Woodbrook Phase 1

Quality Audit

Aeval

October 2019

Purpose: PLANNING			
Title: PHASE 1 TEMPORARY DART STATION CAR PARK LAYOUT			
Original Scale: 1:250 at A1 1:500 at A3	Design/Drawn: AK Date: 26.06.19	Checked: JW Date: 26.06.19	Authorised: KB Date: 26.06.19
Status: P	Drawing Number: 5154251 / HTR / DR / 0120	Rev: D

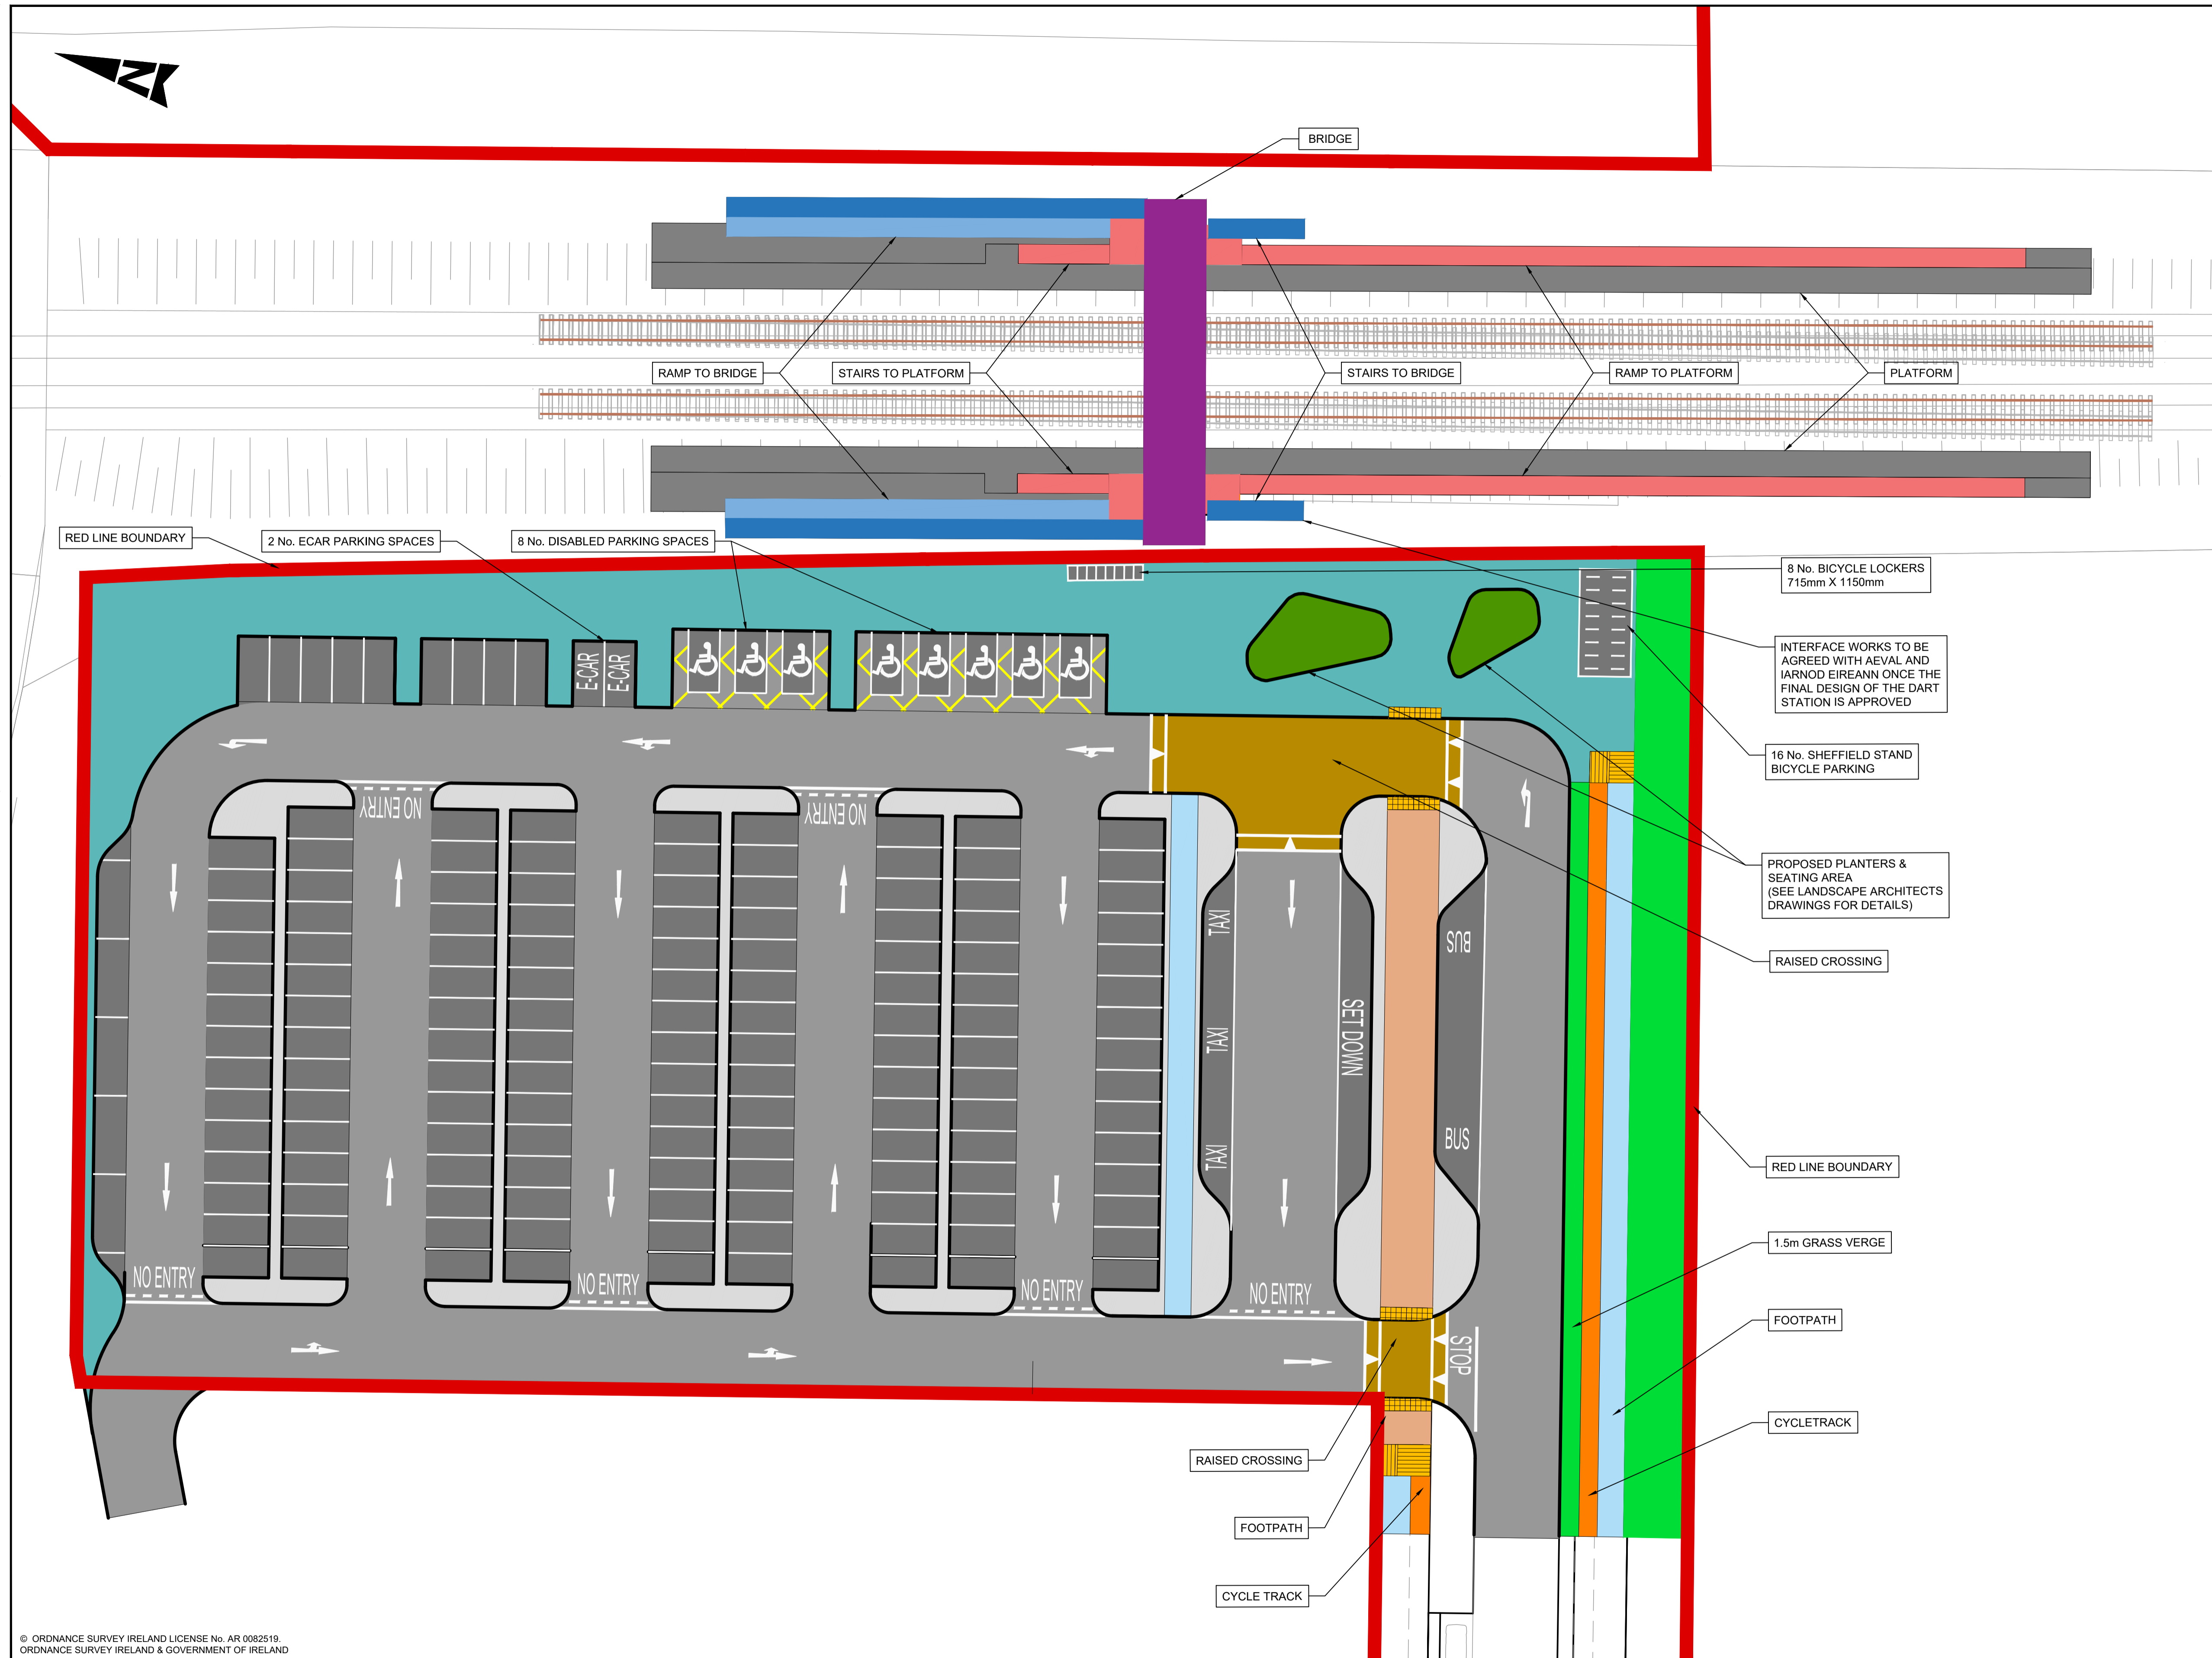
2.3.1. Problem: Inadequate Mobility Impaired Provision

Location: 5154251/HTR/DR/0120: Wheelchair Parking in Car Park

Dropped kerbs are not indicated at the wheelchair parking bays. This may create difficulty for wheelchair users to access the station and lead to conflict.

Recommendation

The Designer should make adequate provision for wheelchair users as part of the design.

2.3.2. Problem: Inadequate Mobility Impaired Provision

Location: 5154251/HTR/DR/0120: Train Station

Details of a lift to facilitate wheelchair users and mobility impaired is not indicated at the train station. This may create difficulty for those wishing to access the train platform.

Recommendation

The Design should consider how mobility impaired will access the train platforms.

Purpose	PLANNING
Title	PHASE 1 DUBLIN ROAD ENTRANCE LAYOUT
Original Scale	N.T.S.
Design/Drawn	AK
Checked	JW
Authorised	KB
Date	24.06.19
Date	24.06.19
Date	24.06.19
Status	P
Drawing Number	5154251 / HTR / DR / 0119
Rev	B

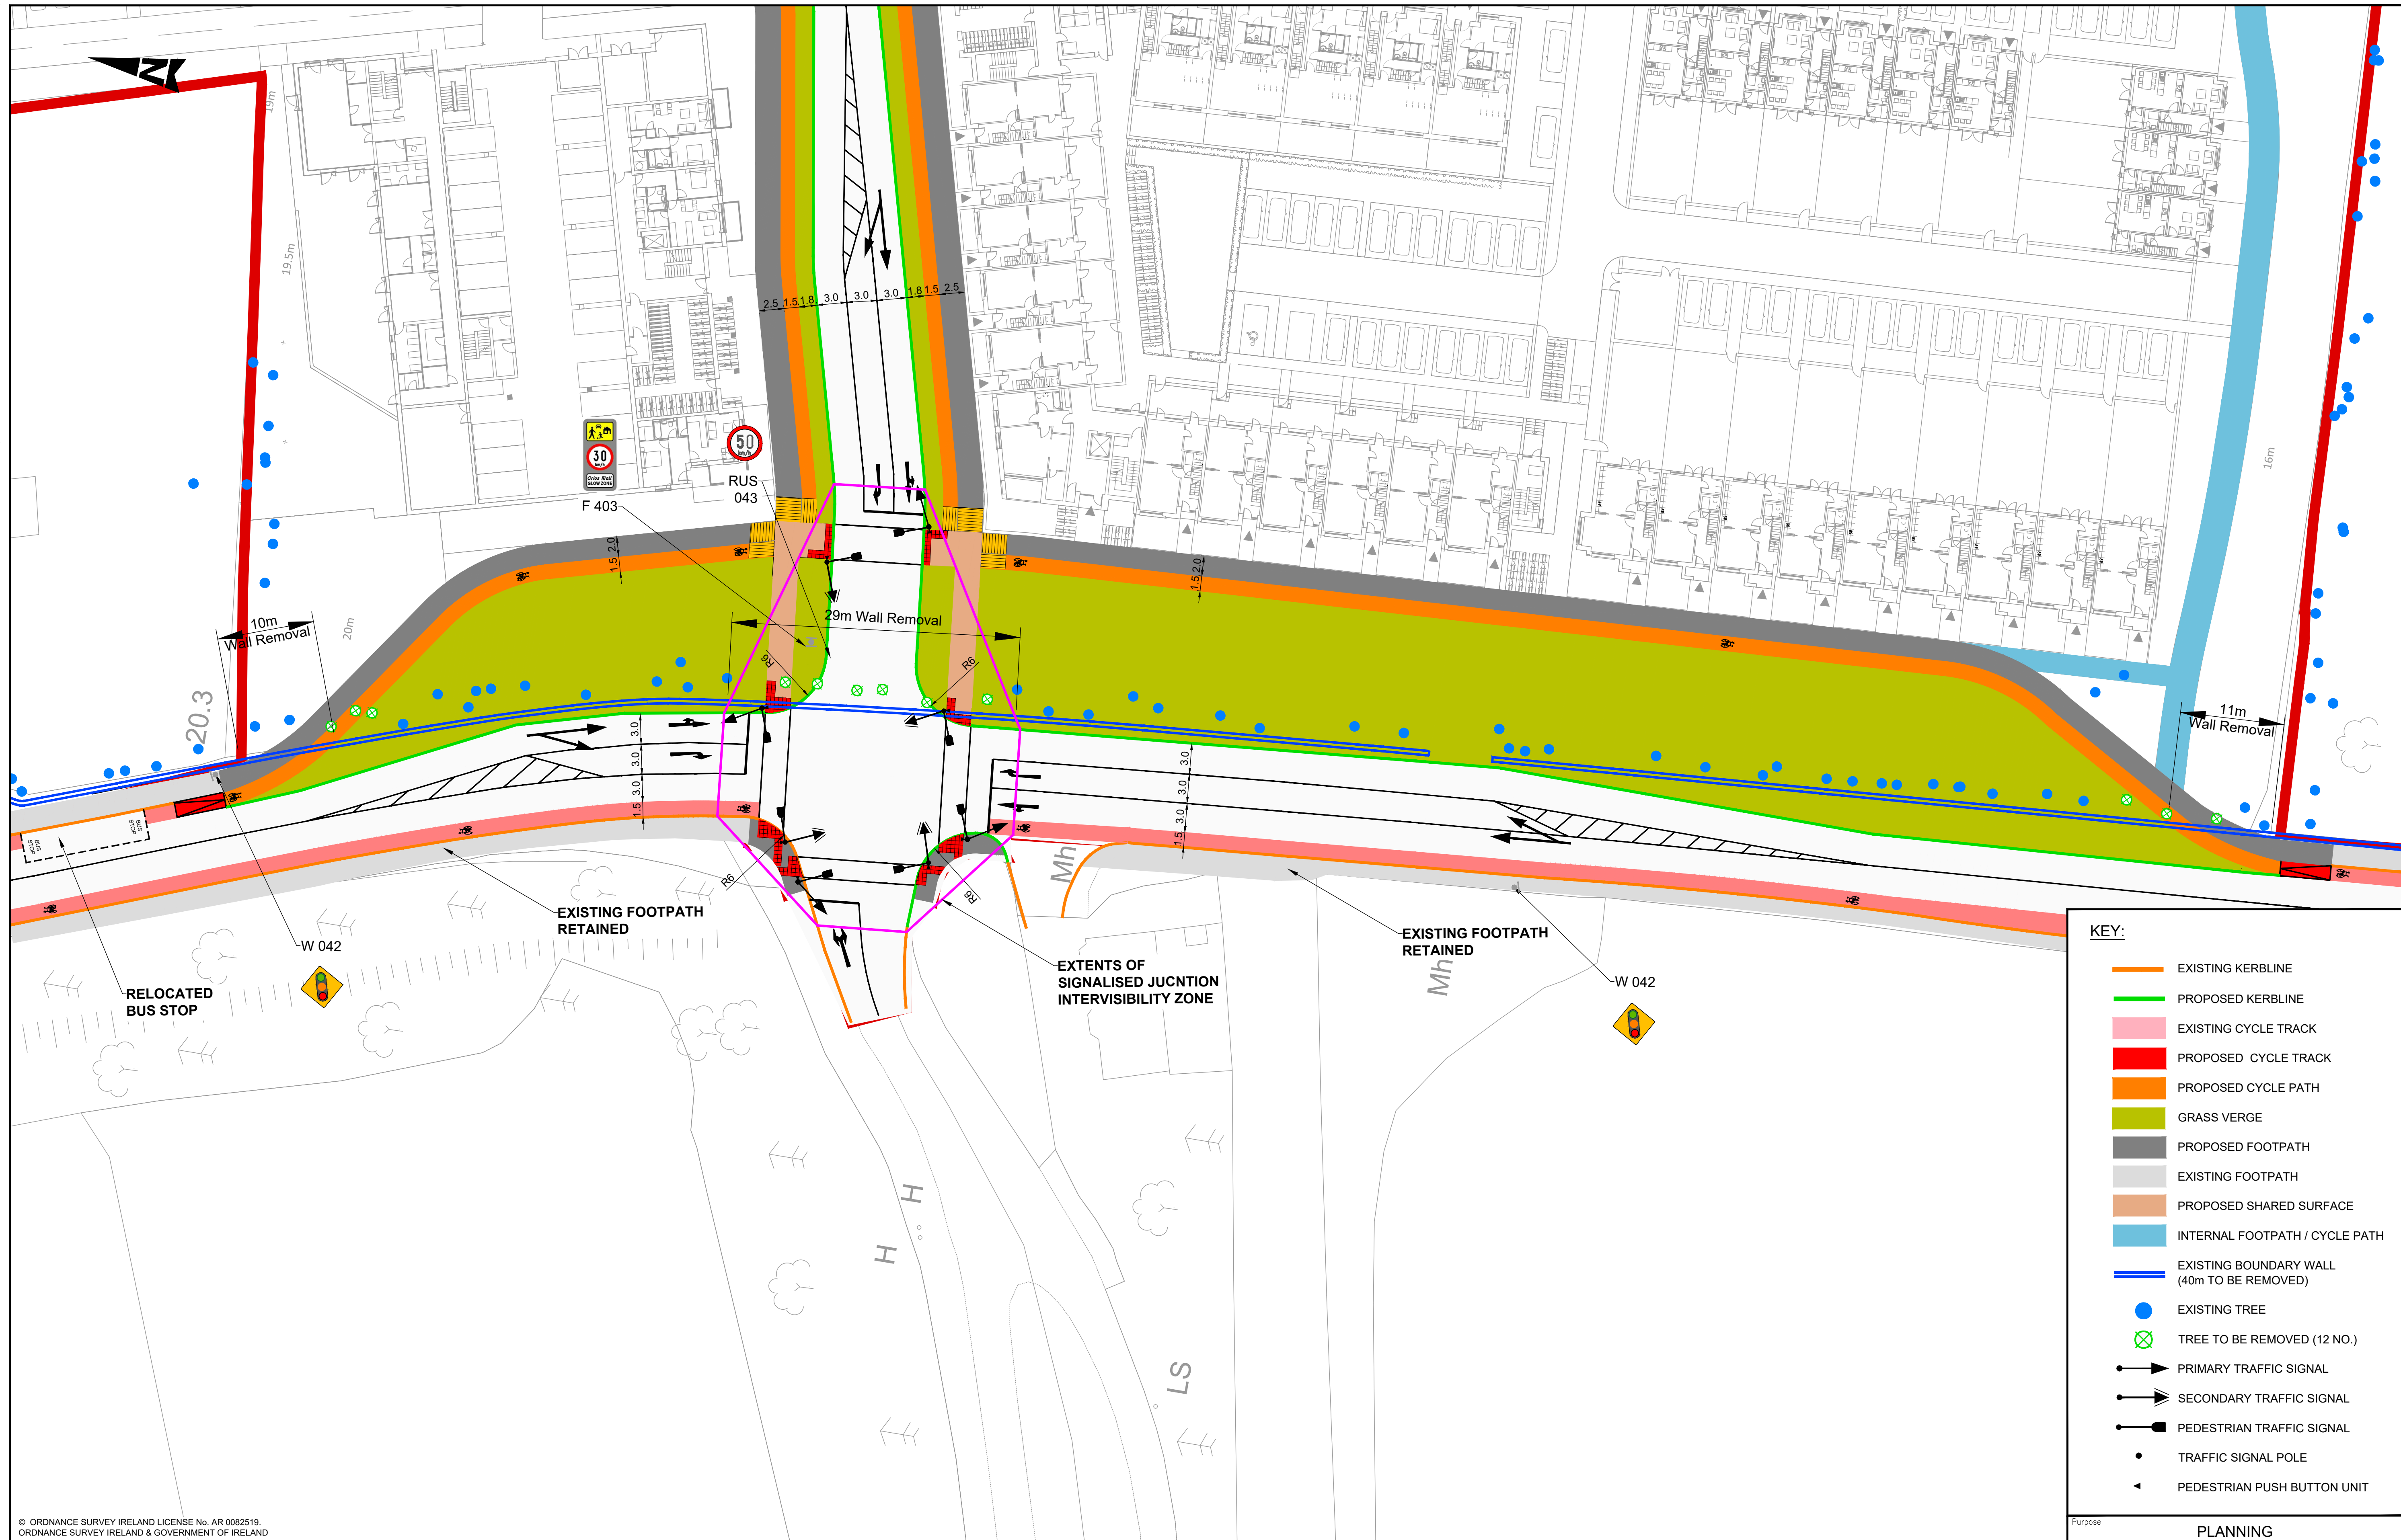
3.4. Problem: Inadequate Pedestrian Provision

Location: 5154251/HTR/DR/0119: South-west of Traffic Signals

An existing access is located in proximity to the traffic signal. The junction may not adequately serve vulnerable road users and may lead to conflict.

Recommendation

The Designer should make adequate provision for vulnerable road users cross the junction.

2.6. Problem: Convergence of Opposing VRU Streams

Location: 5154251/HTR/DR/0119: Ped Crossing to East of Traffic Signal

2 Cycle tracks and a shared use area converge in proximity either side of the toucan crossing. There is a risk of conflict where 4 opposing streams of VRUs converge particularly by the presence of cyclists.

Recommendation

The Designer should consider setting back the tramlines from the toucan crossing thereby increasing the distance between the converging VRUs.

2.7. Problem: Conflicting Road Markings

Location: 5154251/HTR/DR/0119: Cycle Track along West of Traffic Signal

The cycle track road markings continue through the pedestrian crossing. Additionally, a stop line has not been provided for the cycle track. This may lead to confusion and conflict.

Recommendation

The Designer review the marking at this location ensuring provision of a stop line. The cycle track marking should not continue through the crossing.

2.8. Problem: Inadequate Inter-visibility

Location: 5154251/HTR/DR/0119: East of Traffic Signal

The existing boundary wall and various trees are proposed to be retained as part of the scheme. This may hinder inter-visibility between VRUs and traffic leading to conflict.

Recommendation

The Designer should ensure adequate inter-visibility is provided between vehicles and vulnerable road users at this location.

2.9. Problem: Foliage Blocking Traffic Signals

Location: 5154251/HTR/DR/0119: Traffic Signals

Existing overhanging foliage could restrict visibility to the traffic signal heads and lead to conflict.

Recommendation

The Designer should make provision for the removal of any foliage which might block visibility to the traffic signals.

2.10. Problem: Restricted Visibility to Traffic Signals

Location: 5154251/HTR/DR/0119: Traffic Signals

A bus stop is located a short distance to the north of the traffic signal. Stationary buses may hinder the visibility of the traffic signals leading to conflict. The downhill gradient may increase speed and thus increase the risk of conflict.

Recommendation

The Designer should consider measures to ensure visibility of the traffic signals.

2.11. Problem: Set-back of Crossing from Desire Line

Location: 5154251/HTR/DR/0119: East of Traffic Signals

The crossing on the east of the junction is set-back a considerable distance from the likely desire line for the north-south movement. This may lead to some vulnerable road users failing to utilise the dedicated crossing and lead to conflict.

Recommendation

The Designer should review the distance between the toucan crossing to the east and the main junction.

2.6	Y	Y		
2.7	Y	Y		
2.8	Y	Y		
2.9	Y	Y		
2.10	Y	Y	As an interim measure the inline Bus Stop will be	Y

relocated to a suitable location away from the junction. The inline bus stop will be replaced with an improved bus stop provision as part of a future bus improvement scheme.	
2.11	Y	N	The footpath and cyclepath have been setback the minimum distance to allow for retention of existing trees in line with the requirements of the Woodbrook\Shanganagh LAP. Balance of risks have been assessed and this falls within reasonable grounds.	Y
